JOB Cabin Mountain Tree Farms LL-08-06

To: Trudie Pettit, Staff Planner
From: Michelle Geiger, Plans Examiner Kittitas County Community Development Services
Date: May 30, 2008
Re: Cabin Mountain Tree Farm Tracts Large Lot, LL-08-06 & Cabin Mountain Tracts Large Lot, LL-08-07

TO: Trudie Pettit, Community Development Services
FROM: Randy Carbary, Planner II *RC*
DATE: May 7, 2008
SUBJECT: Cabin Mountain Tracts Large Lot Subdivision LL-08-00007

TO: Trudie Pettit, Community Development Services
FROM: Randy Carbary, Planner II *RC*
DATE: May 30, 2008
SUBJECT: Cabin Mountain Tree Farm Tracts Large Lot Subdivision LL-08-00006

CABIN MOUNTAIN TRACTS LARGE LOT SUBDIVISION A PORTION OF SECTION 8, TOWNSHIP 20N., RANGE 13E., W.M. KITKITAS COUNTY, WASHINGTON

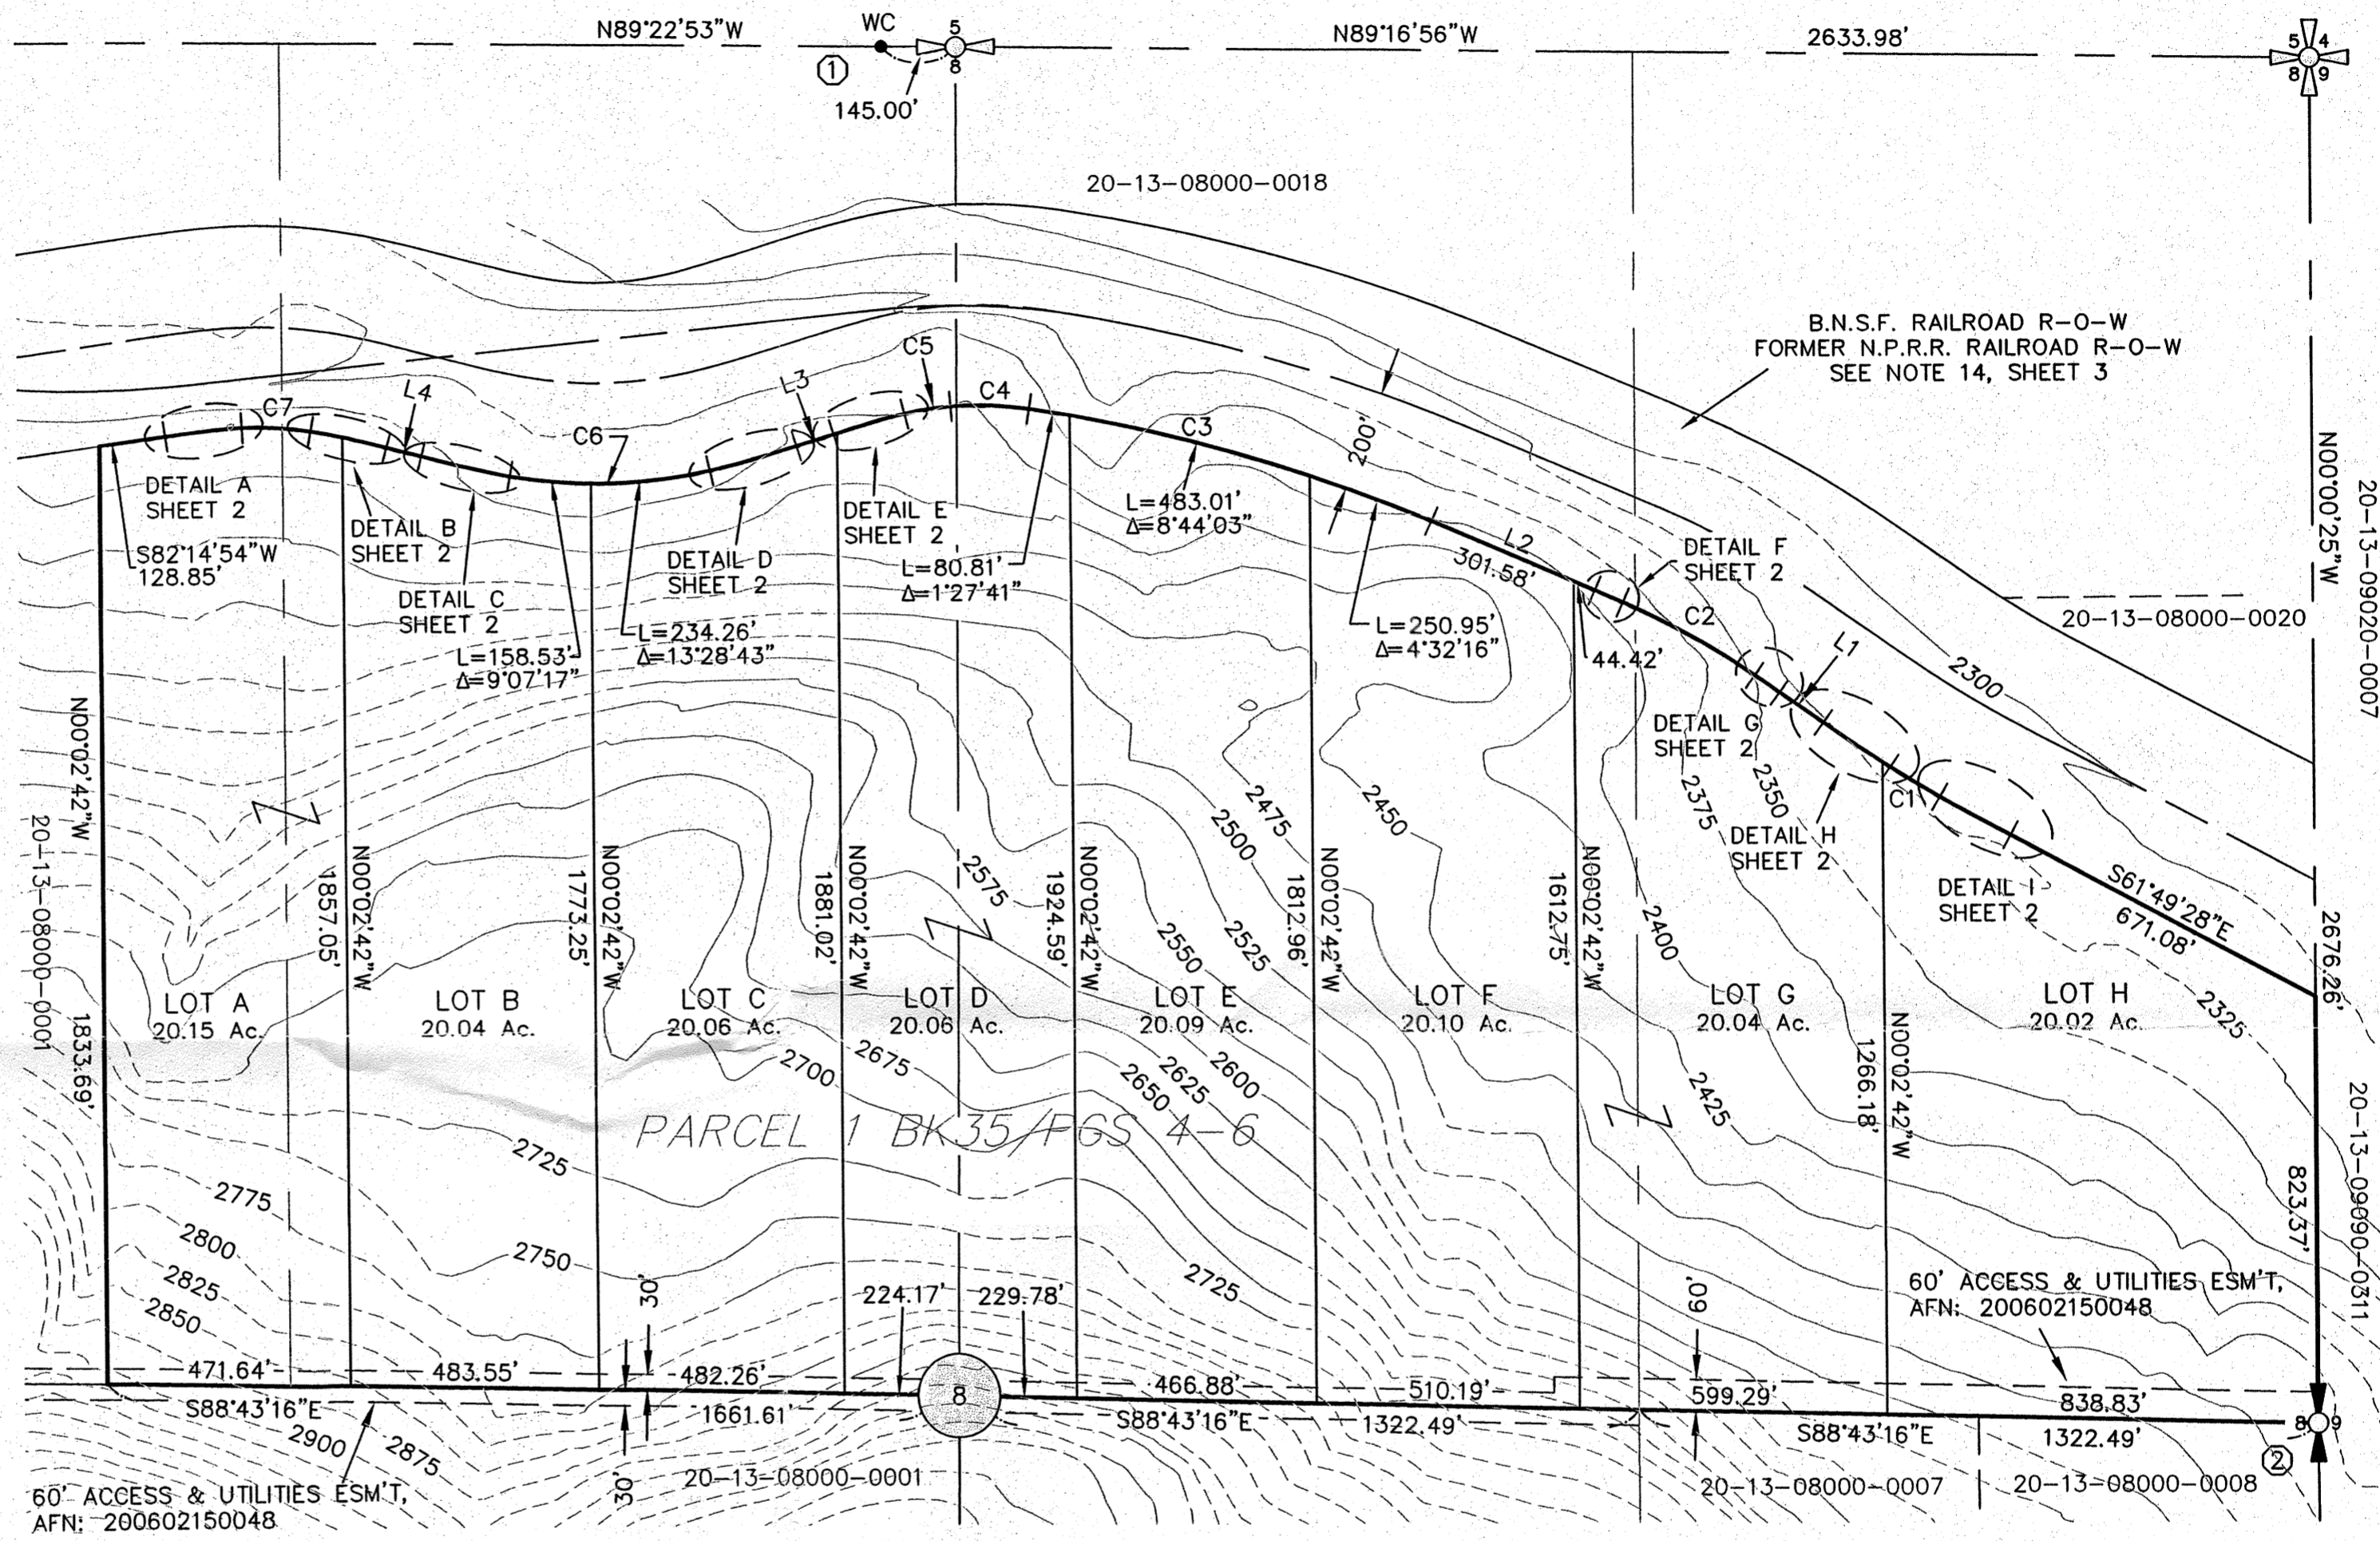
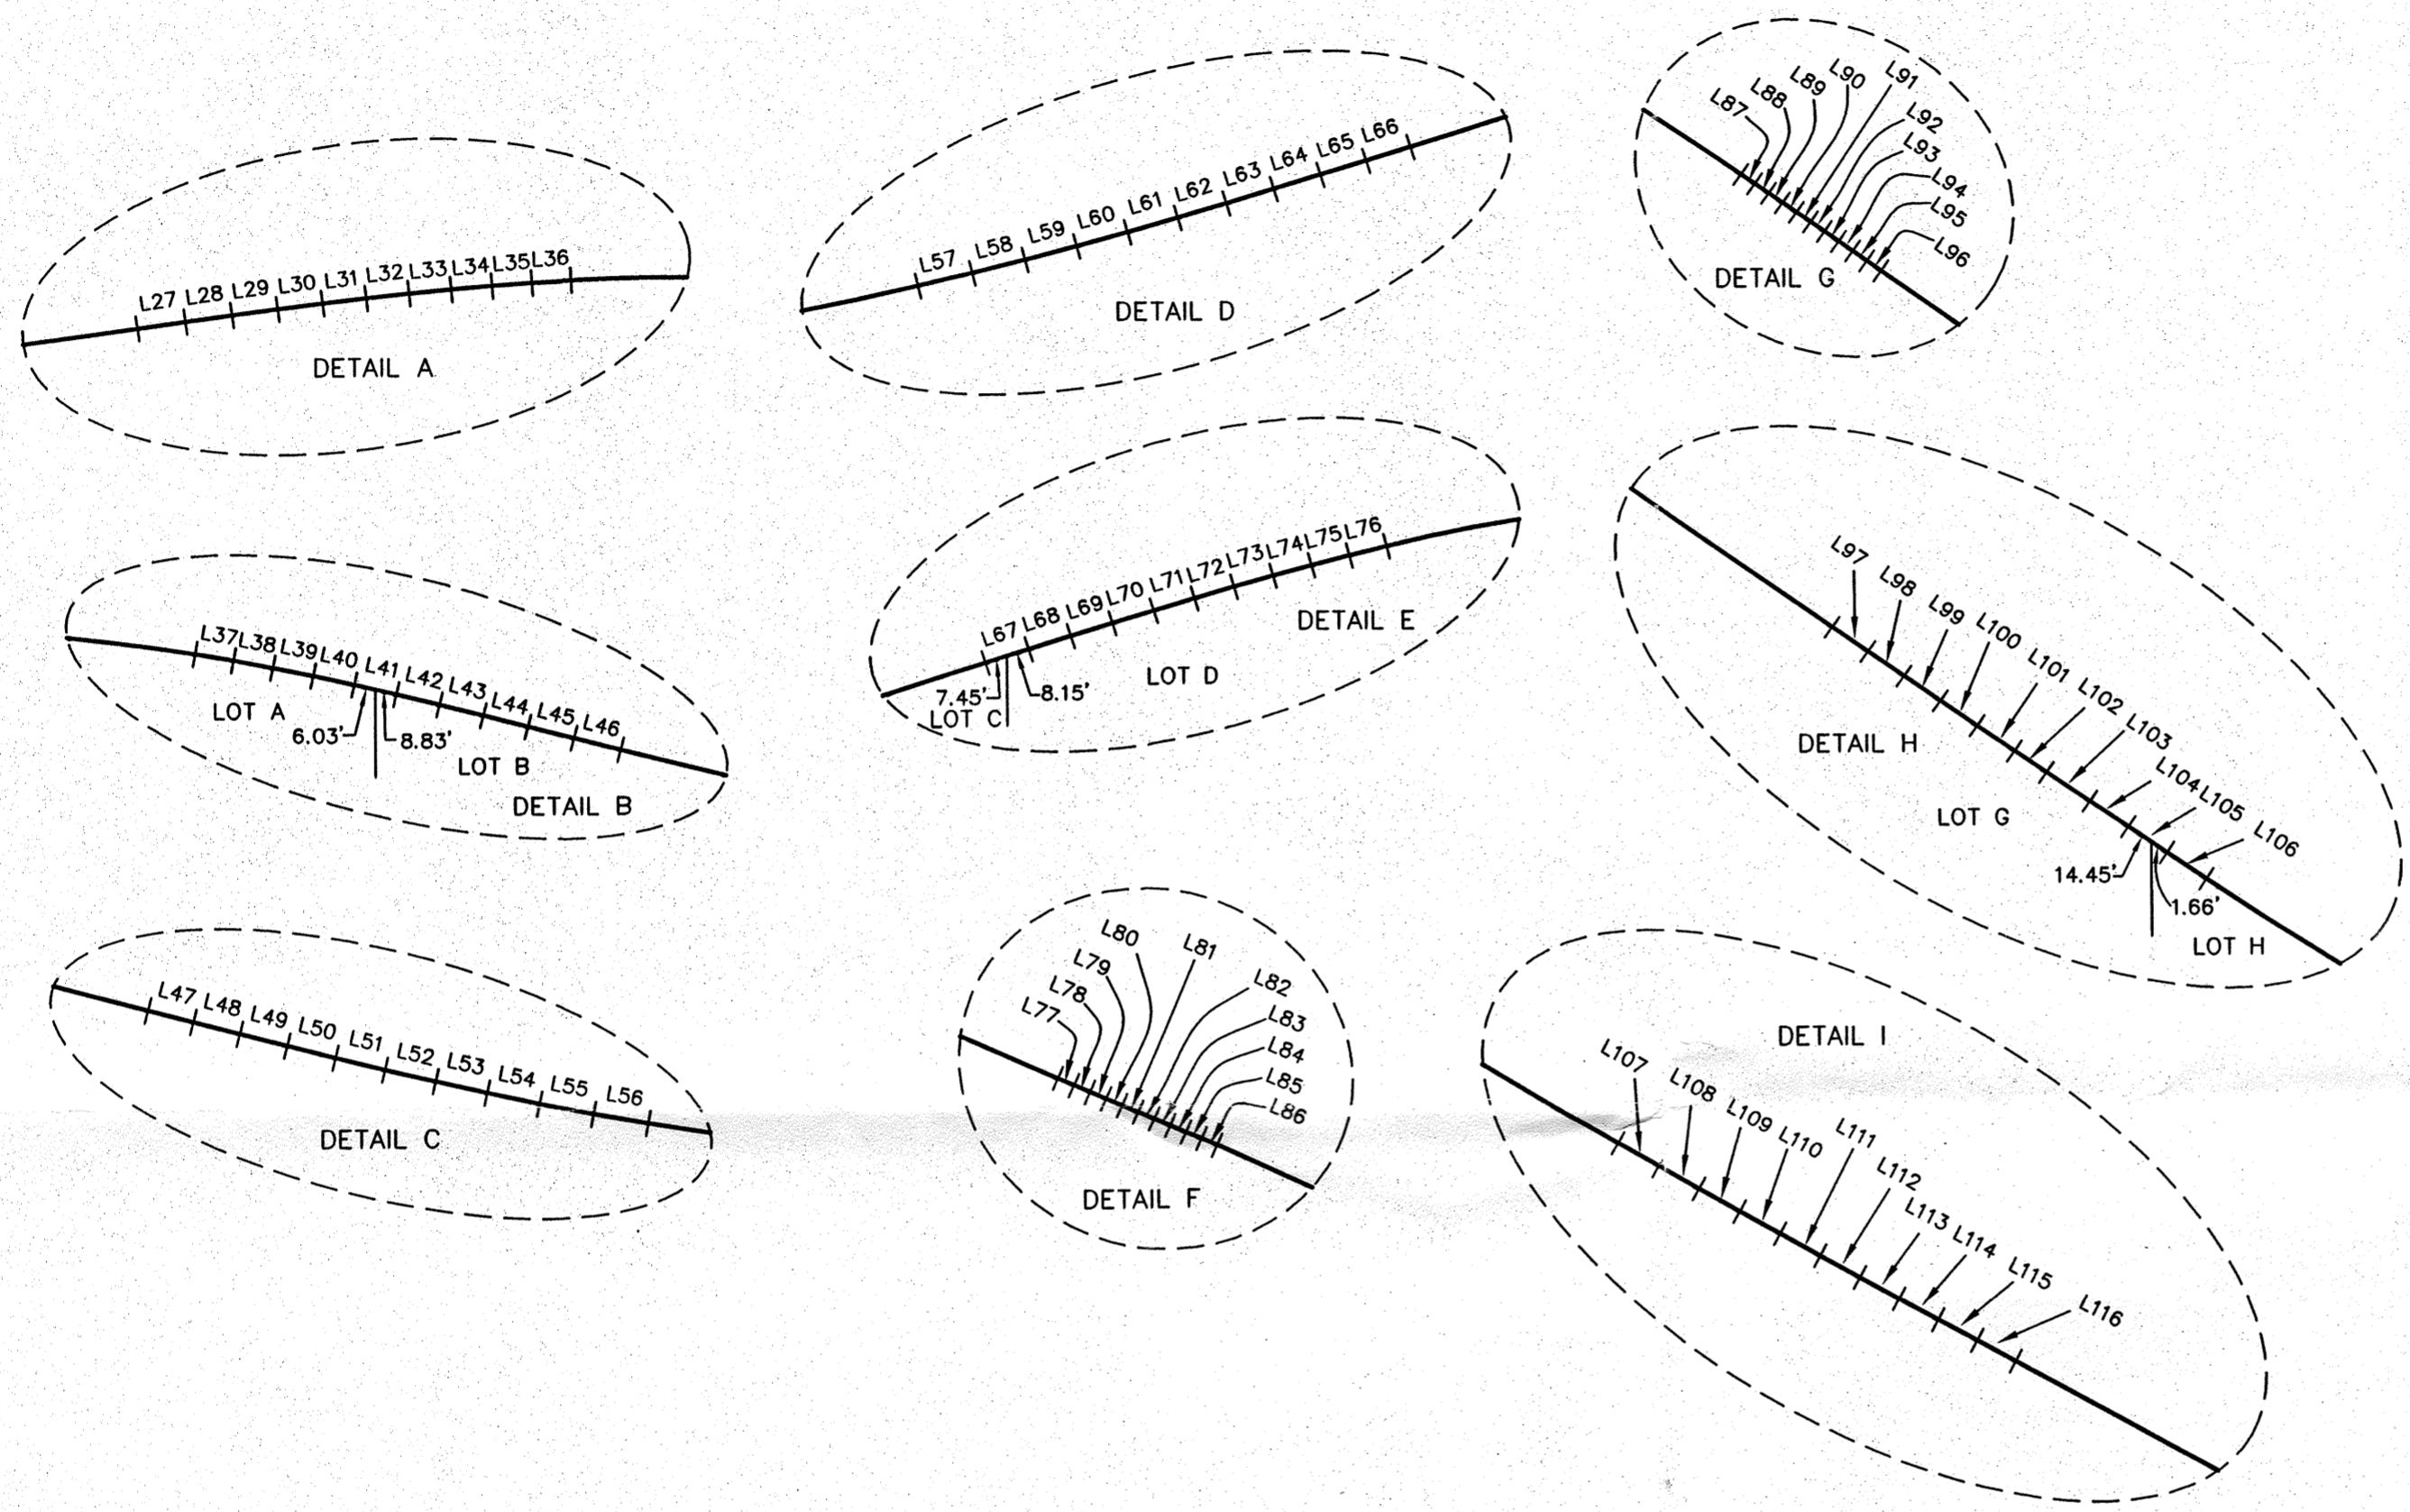
1. **Cul-de-Sac:** No cul-de-sac or turn around area is identified on the Large Lot Subdivision application. A cul-de-sac turn-around having an outside right-of-way easement diameter of at least 110 feet shall be constructed at the closed end of all dead-end roads serving 3 or more lots. The driving surface shall be at least 96 feet in diameter. Cul-de-sacs must also conform to the requirements specified by the 2006 International Fire Code. Contact the Fire Marshal regarding any additional cul-de-sac requirements.

The location of the cul-de-sac or turn around area shall be depicted on the face of the Large Lot Subdivision application, prior to final approval of the Large Lot Subdivision., regardless of its location.
